North Falls Offshore Wind Farm Ltd – EN010119

Section 51 advice regarding draft application documents submitted by North Falls Offshore Wind Farm Ltd

On 24 May 2024 North Falls Offshore Wind Farm Ltd submitted the following draft documents for review by the Planning Inspectorate as part of its Pre-application Service¹:

Scale	Plot Size	Datum	Projection
1:50,000	A1	WGS84	UTM31N

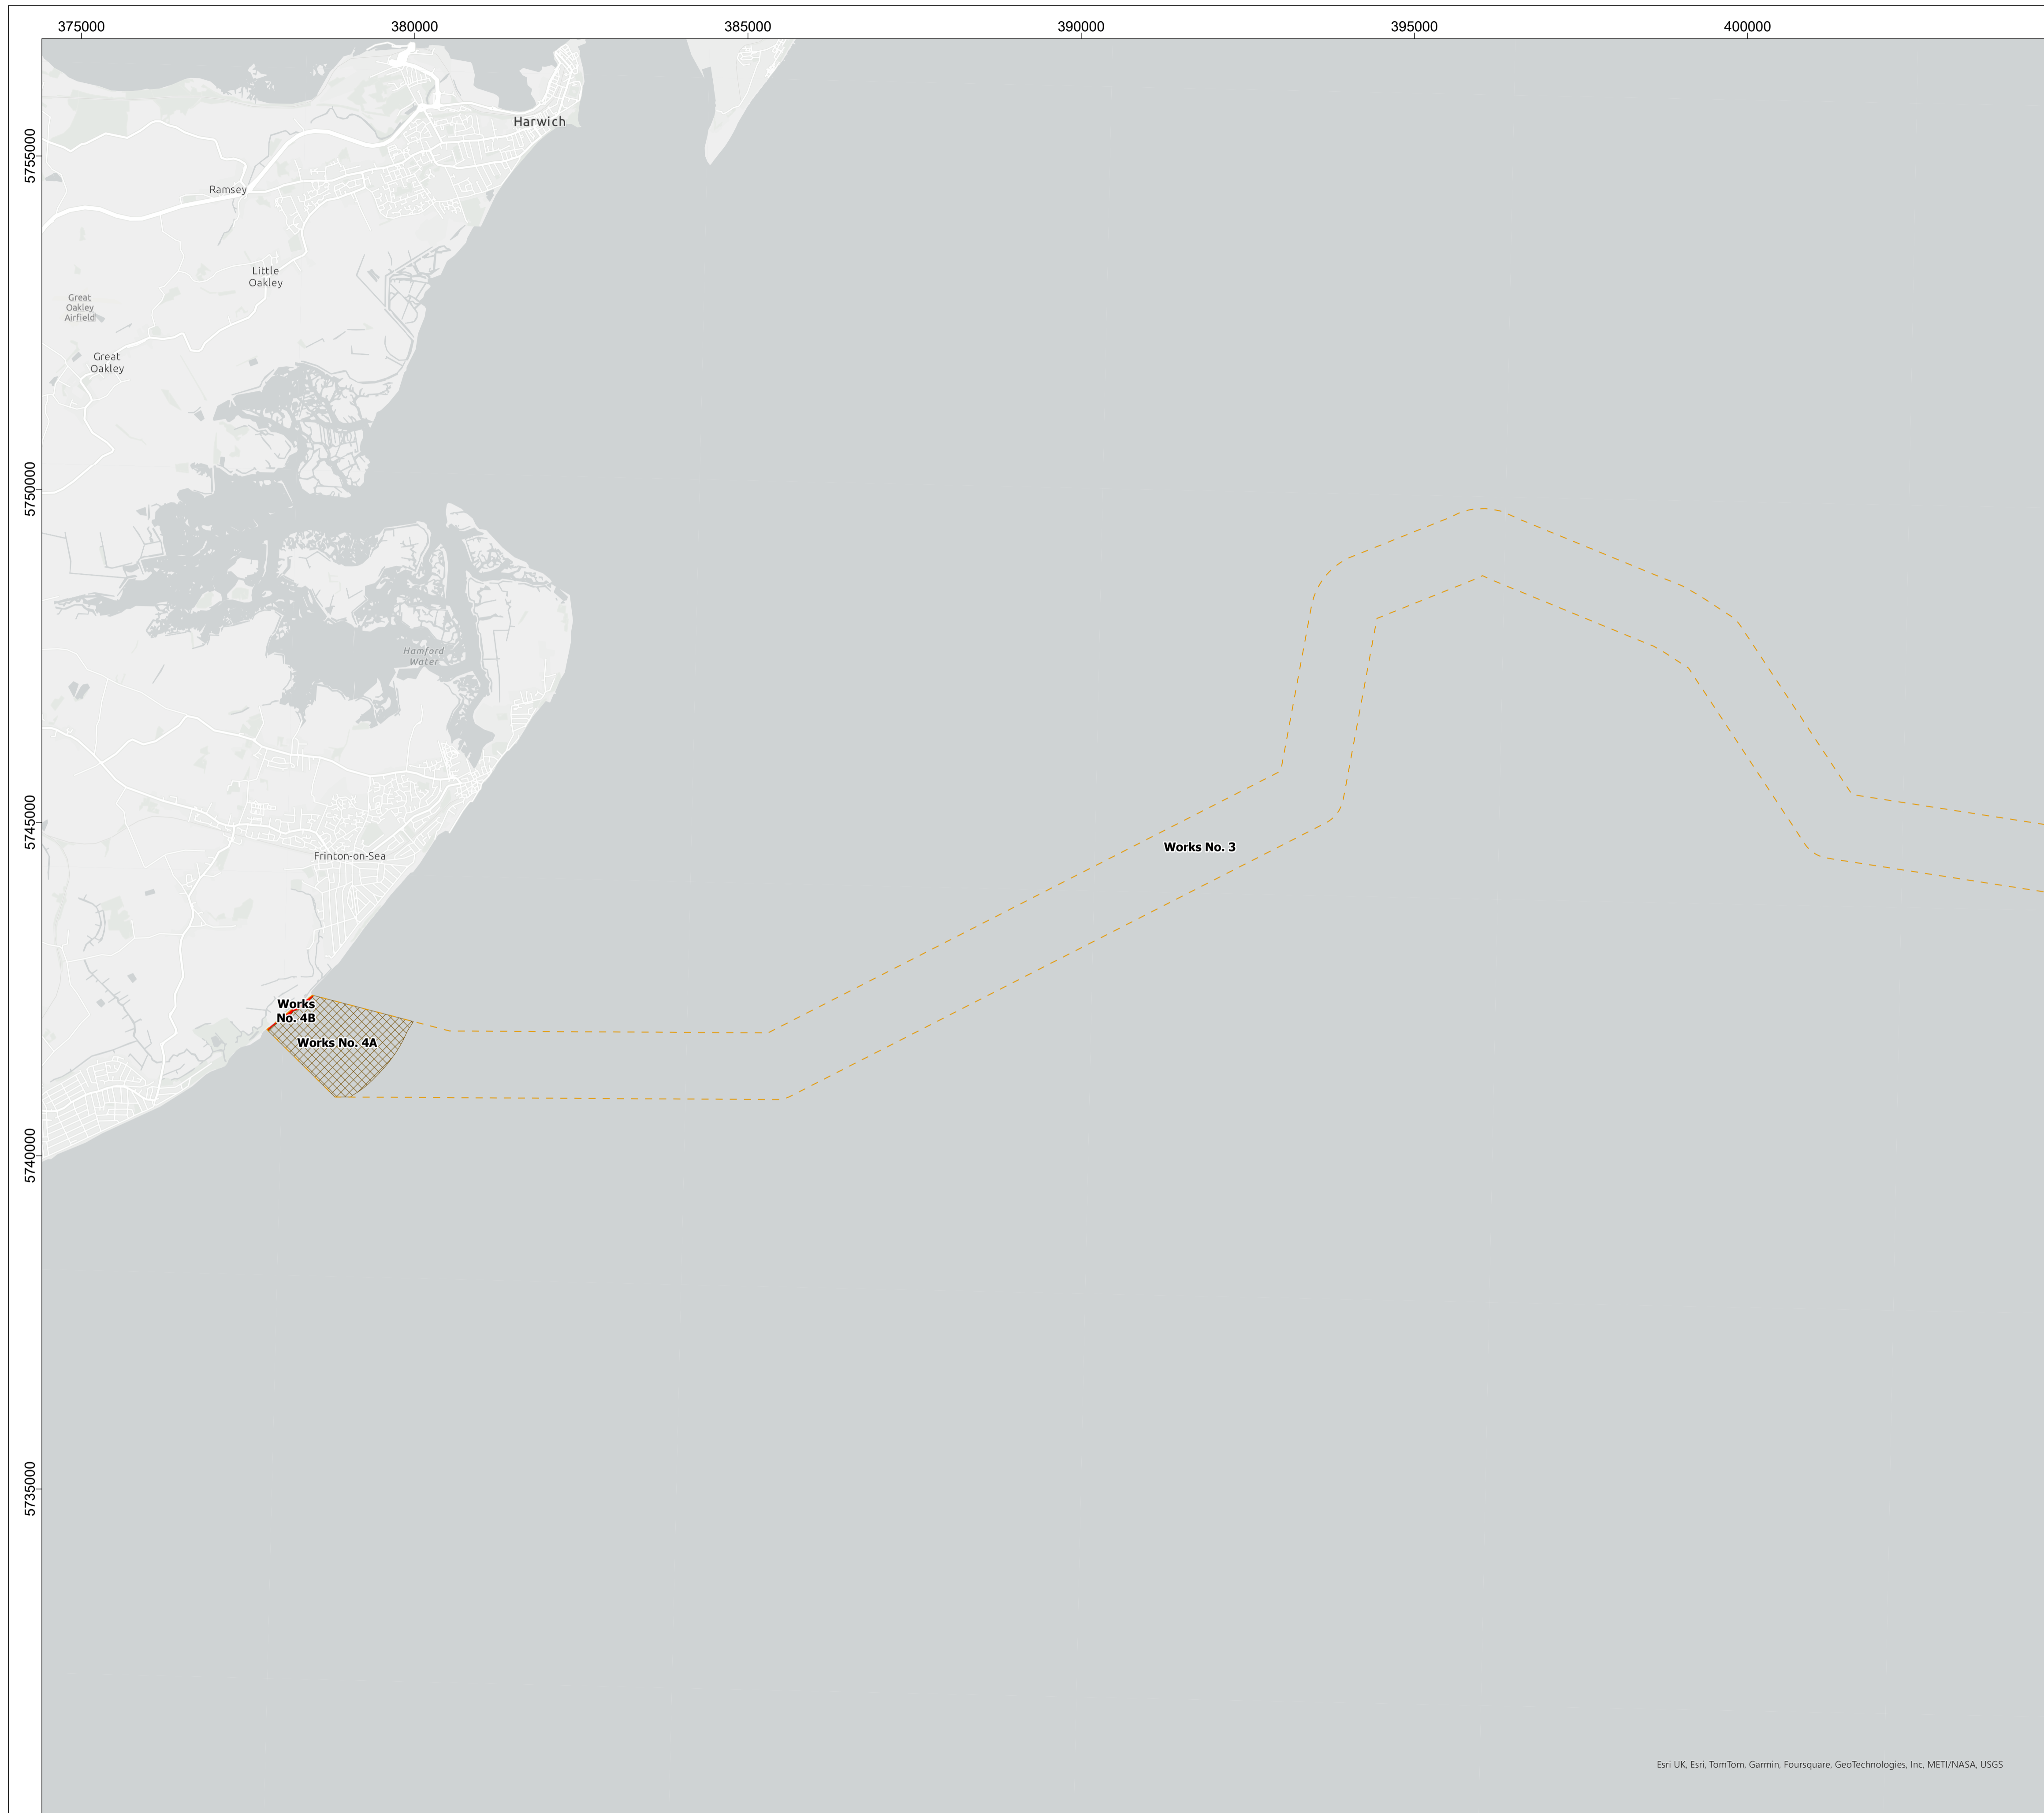
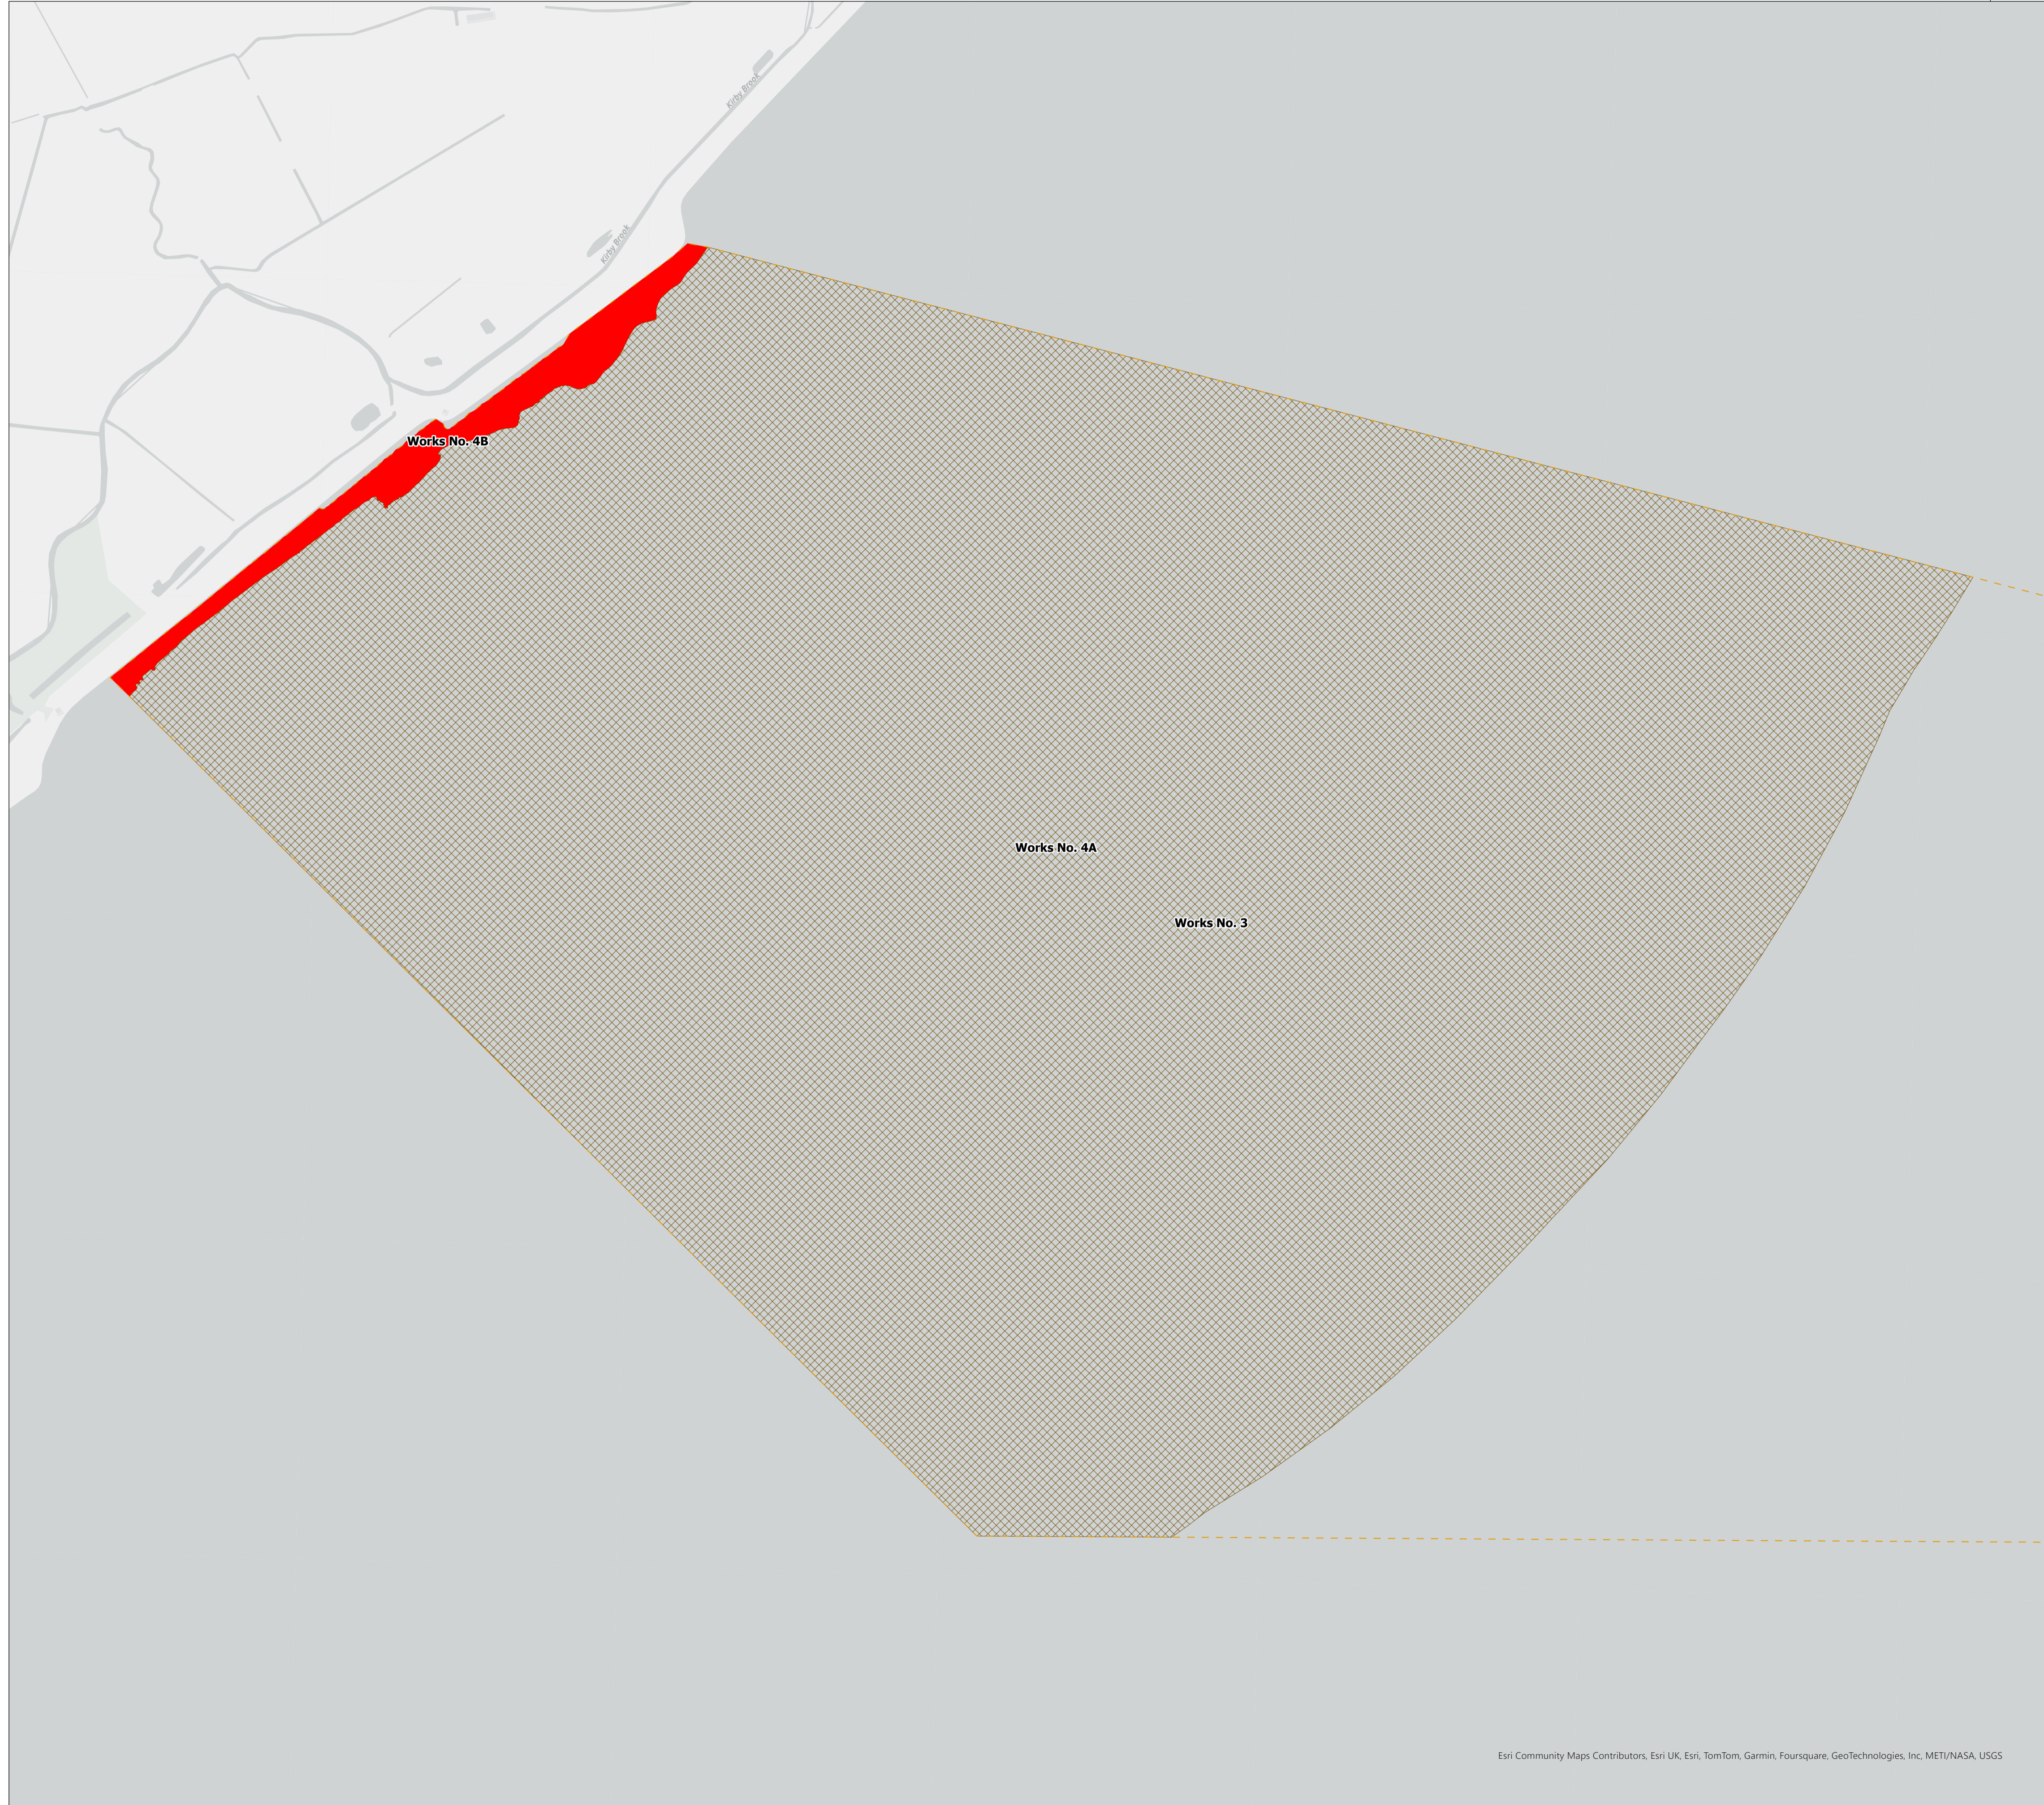
Offshore plans		
Ref.	Plan ref	Comment or question
11.	Works No.4A	Within the Legend an abbreviation is used 'HDD' that is not explained. For ease of understanding, the Applicant may wish to consider using the full term rather than an acronym.
